**KIRKLEES METROPOLITAN COUNCIL
INVESTMENT & REGENERATION SERVICE**

DELEGATED DECISION TO DETERMINE PLANNING APPLICATIONS

Reference No:	2021/62/93531/E
Site Address:	20, Station Road, Batley, WF17 5SU
Description:	Alterations to convert auction house and one flat to 19 no. one bedroom suites, basement communal living space, waste and re-cycling storage (Listed Building within a Conservation Area) for Class C2 use
Recommending Officer:	Alex Cowling

DECISION - Refused

Title: First Floor Alterations Plan

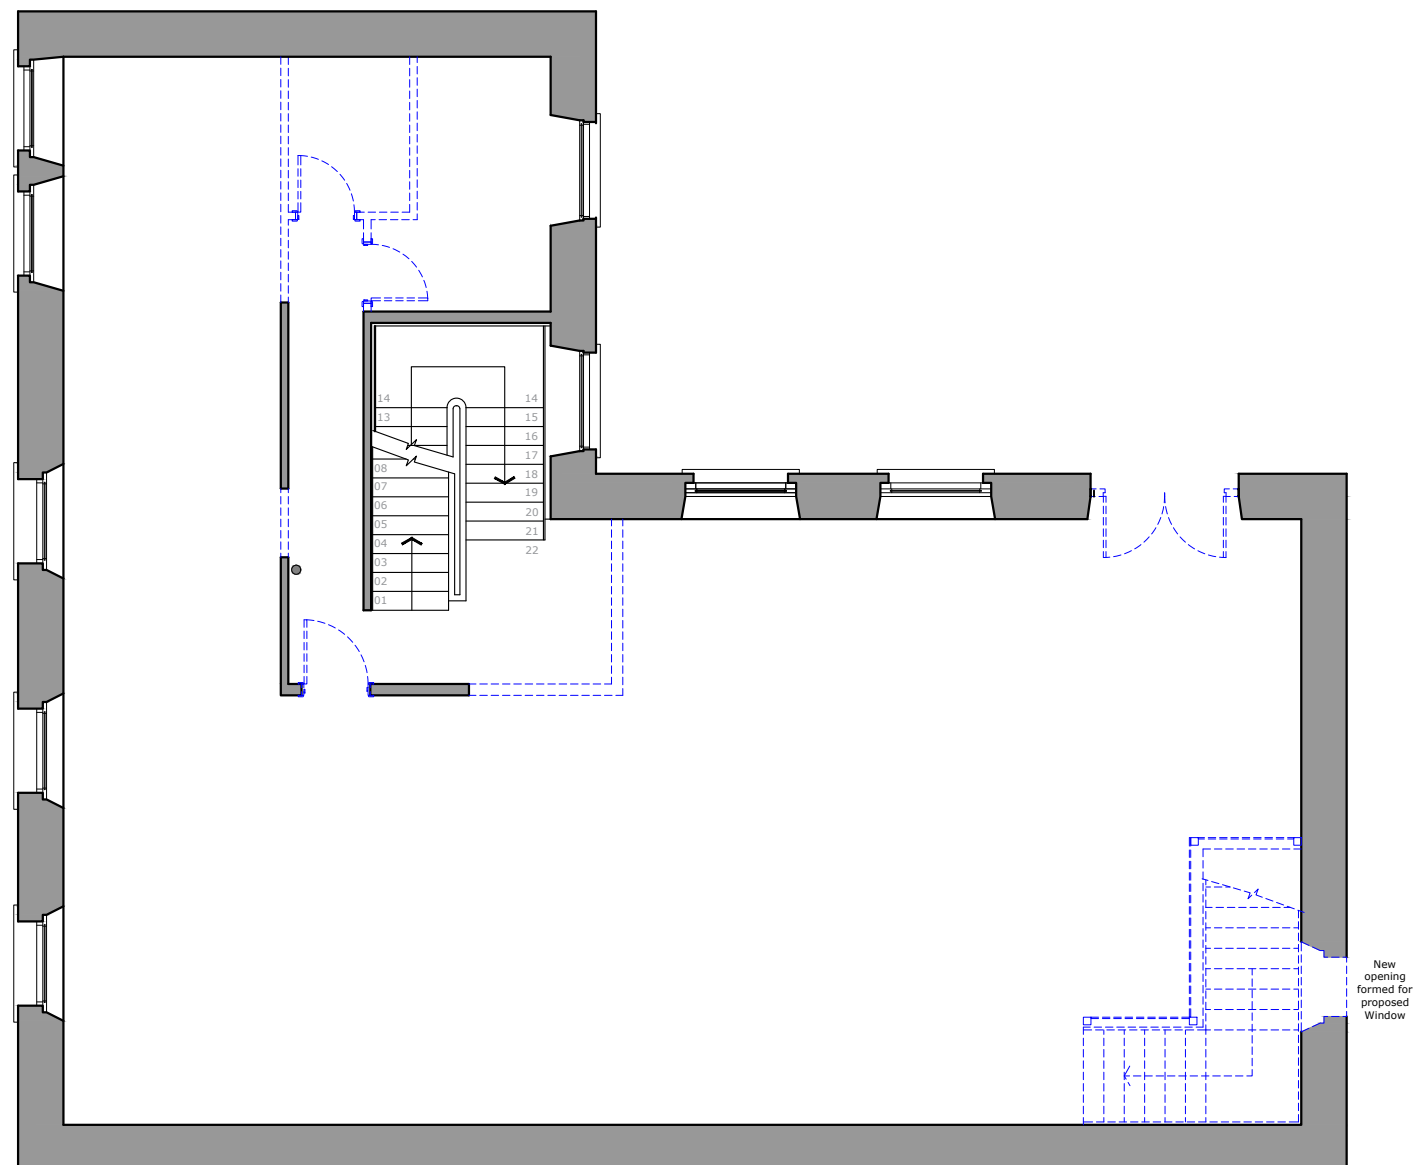
The staircase between the ground and first floor at the rear (west end) of the building is modern and not considered to contribute to the significance of the Listed Building. The proposals to create a lightwell within the courtyard would not cause any significant harm to the Listed Building.

Date: May 2020	Scale: 1:100 (A3)	Checked: PS
Project: 1780	Dwg No: A2-06	Revision: G

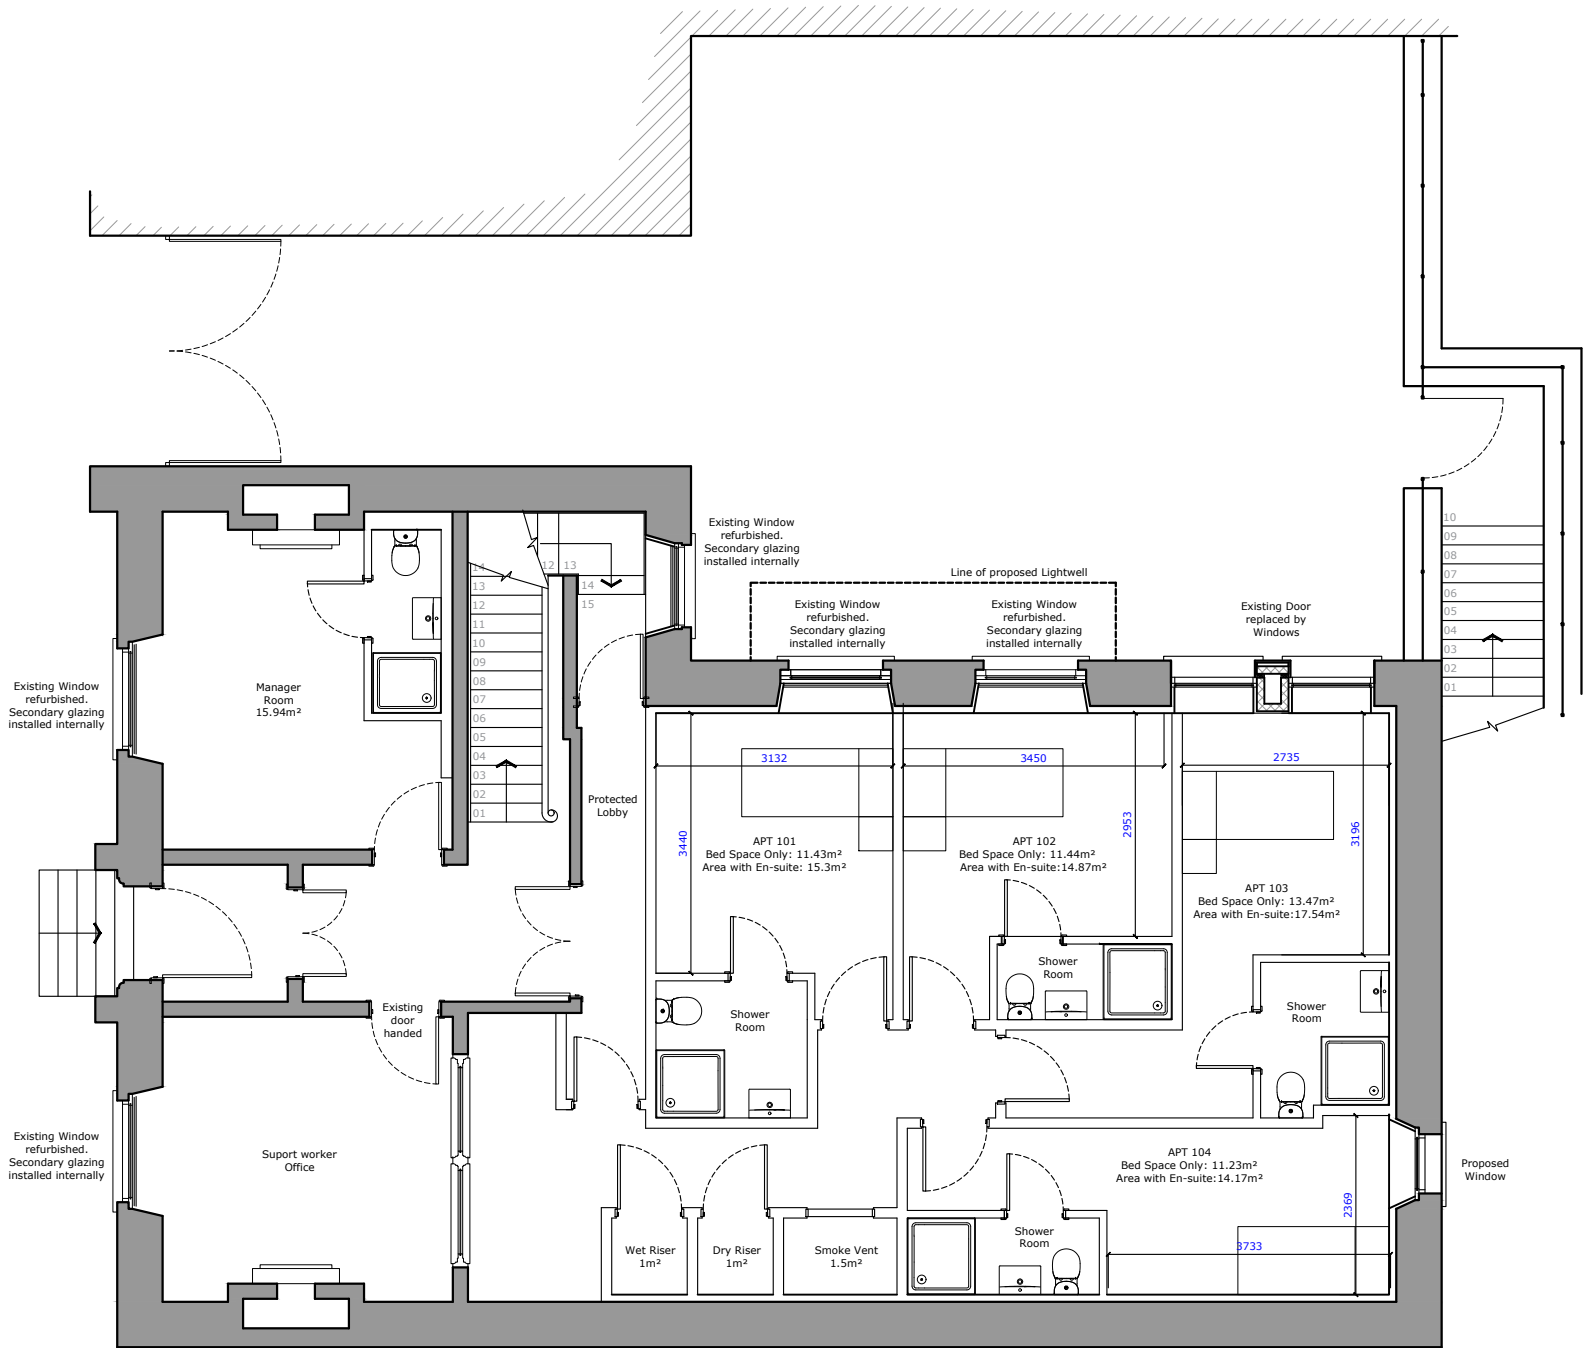
The proposal would provide a total communal living space for the 19 residents of 91.05m², the smallest bedroom (inclusive of en-suite) size is 14.17m² and the largest is 23.54m². Taking into account the limited amount of communal space available to serve 19 individual people, it is considered the proposal will fall short of providing adequate internal space to ensure a reasonable level of amenity. In addition the proposal to accommodate living accommodation within a basement with no reasonable outlook, and limited natural light would be detriment to the amenity of future residents.

The proposed alterations would cause a high level of harm to the interior of the listed building. It is proposed to dryline the walls, which would result in the loss or alteration of many of the original features which form part of the significance of the building. The introduction of drylining would see the loss of internal decorative joinery and plasterwork features of architectural interest are retained and repaired. Their loss cannot be justified and is unnecessary. Listed buildings are exempt from compliance with the energy efficiency requirements of Part L of the Building Regulations to the extent that the requirements would unacceptably alter the character or appearance of such buildings as is the case here. The proposed changes to the layout would also result in the loss of the fine glazed screen to the north office space. The proposed replacement of the loading doors with new timber infill and windows designed to retain the appearance of doors will cause harm to the significance of the listed building.

The warehouse space would be subdivided into a large number of small units, this would cause harm to the plan form. The plan form of the building does form a part of the significance of the building and the introduction of such high number of subdivisions would remove the legibility and understanding of the building. The conversion would introduce a larger number of new bathrooms, kitchens and associated wiring, plumbing and ventilation required, of which there is limited to no detail provided. However, these elements would further contribute to the impact on the Listed Building.
